EL PASO COUNTY PLANNING & COMMUNITY DEVELOPMENT
SIGN APPLICATION

CLIENT
 ASPEN VIEW HOMES
 FILE NAME:
 4X4 Mesa Parkway & Autumn Glen
 DESIGNER:
 LOREN / AARON

PROJECT NAME:
 THE GLEN
 ACCOUNT MANAGER:
 ELISHA
 DATE & REVISIONS:
 04/11/12

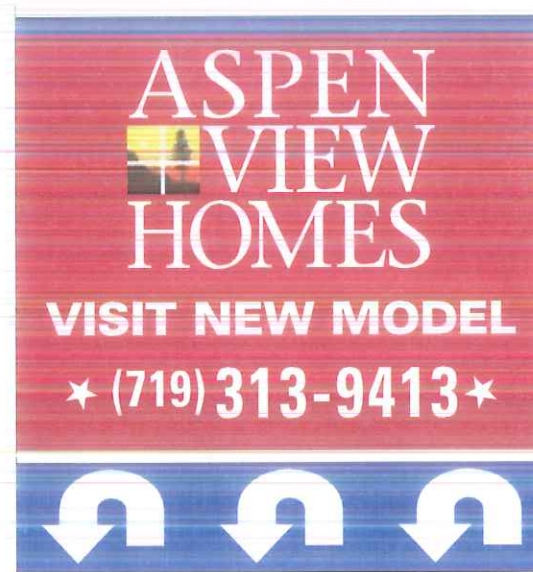
I cannot read this, scan better and include in the sign plan item.
